Recommendation Report for Planning Permission for Works or Extension to a Dwelling

REF NO: BR/232/24/HH

LOCATION: 11 Chichester Road
Bognor Regis
PO21 2XG

PROPOSAL: Proposed loft conversion. Adjustments to the fenestration.

PROPOSED ROOF PLAN
SC. 1:100

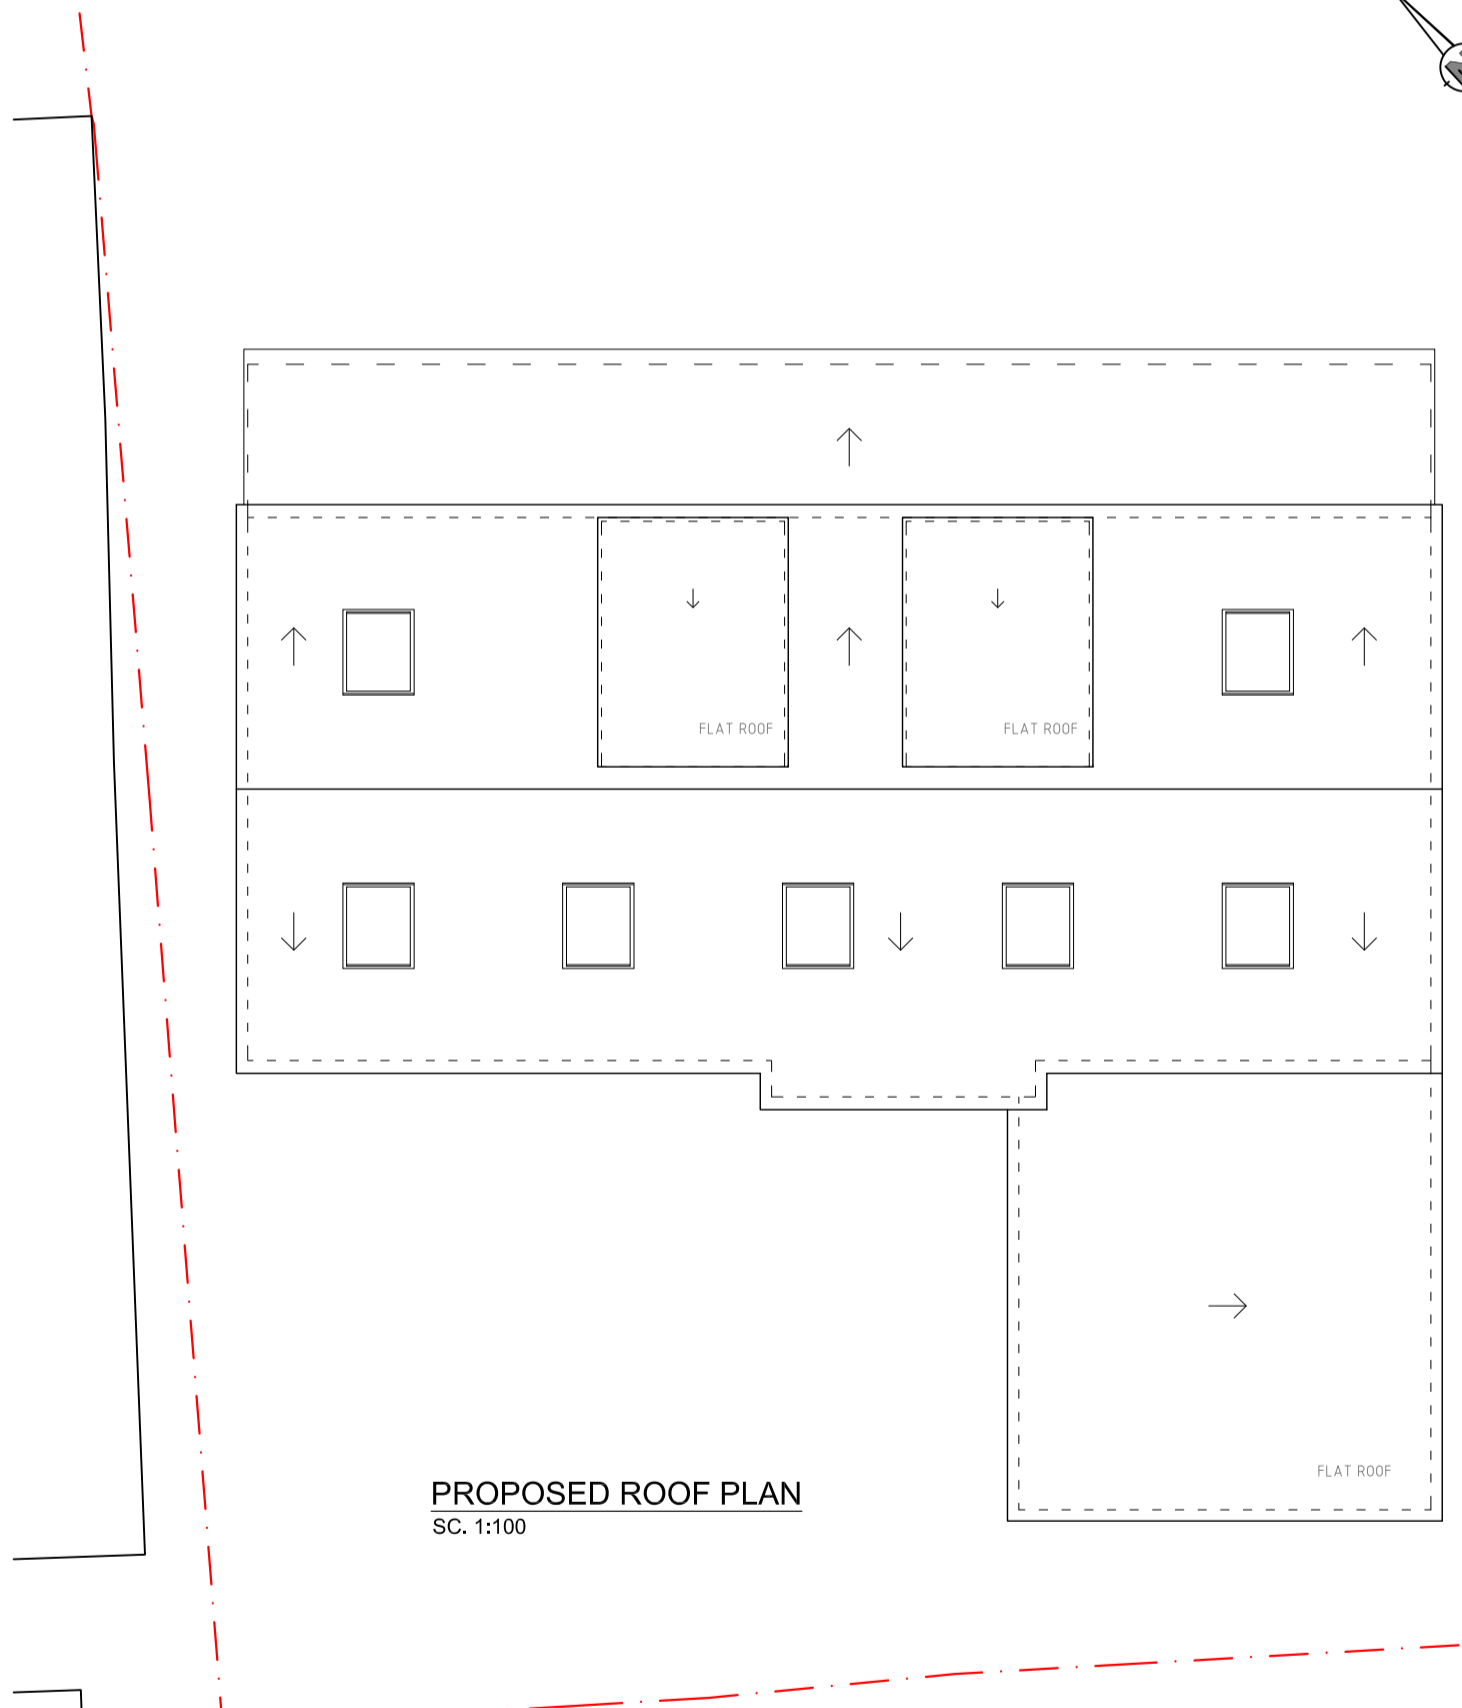
The amended design to install 2 flat roofed dormers to the front elevation is an improvement to the previous application; with the dormers appearing more sympathetic in scale to the main roof. They are a less dominant feature of the roof form than previously, and would appear more reflective of other smaller flat roofed dormers in the vicinity. They measure a maximum height of 8.5m from the ground floor, with a width of approximately 2.5m and projection from the roof slope by 3.2m. Whilst flat roofed dormers are generally less desirable from a design perspective over hipped or gable roof dormers which have more visual appeal, in this case the proposal is not of significant enough harm to visual amenity to warrant a reason for refusal. The dormers are proportional to the roof form, not overly dominant, and integrate with the visual appearance and character of the dwelling itself. Given the varied appearance and character of other properties in the surrounding property, the dormers would not appear unduly out of keeping with the rest of the street scene. As such, the dormers to the front elevation are acceptable.

It is proposed for external walls of the dormers to be clad with weatherboarding (Hardie Plank Cedar) in the colour Grey Slate. There are few examples of weatherboard cladding in the immediate vicinity; however there is use of this material in the wider locality. Given the minor amount of weatherboarding that would be used, its incorporation is acceptable.

In regard to the loft conversion itself, and introduction of rooflights to the front and rear elevation, these works are acceptable given their minor impact on the visual appearance and character of the building. They would have no adverse harm to the visual amenity of the property, or the surrounding area.

The proposal would see the introduction of 2 dormers to the front, at a height of 8.5m; and 7 rooflights at a height of approximately 7.6m. Whilst these would be substantial additions to the roof form, especially in regard to the dormers, their location is such that the impact on residential amenity does not result in demonstrable harm. The dormers to the front would not unduly overbear or overshadow either neighbouring property, and would provide an outlook that overlooks the street scene and roundabout. The dormers would not provide any overlooking opportunities which would result in adverse harm to residential privacy or amenity.

The rooflights to the rear would not be overbearing or overshadowing, by virtue of their location flush to the roof plane; however they would increase the opportunity for overlooking, being on the rear elevation. This elevation abuts the rear gardens of properties in Annandale Avenue and Victoria Drive, providing additional views of the rear elevations. Whilst the location of the rooflights would give some visibility of the rear gardens, due to the nature of the rooflights being sloped, this would be limited. Any views harmful to amenity would only be possible with intention, and such would not be incidental overlooking easily accessible to the viewer.

- 3 The materials and finishes of the external walls and roofs of the building hereby permitted shall match in colour and texture those of the existing building. This is with the exception of the external walls of the dormers, which shall be Hardie Plank Cedar Cladding in Grey Slate.
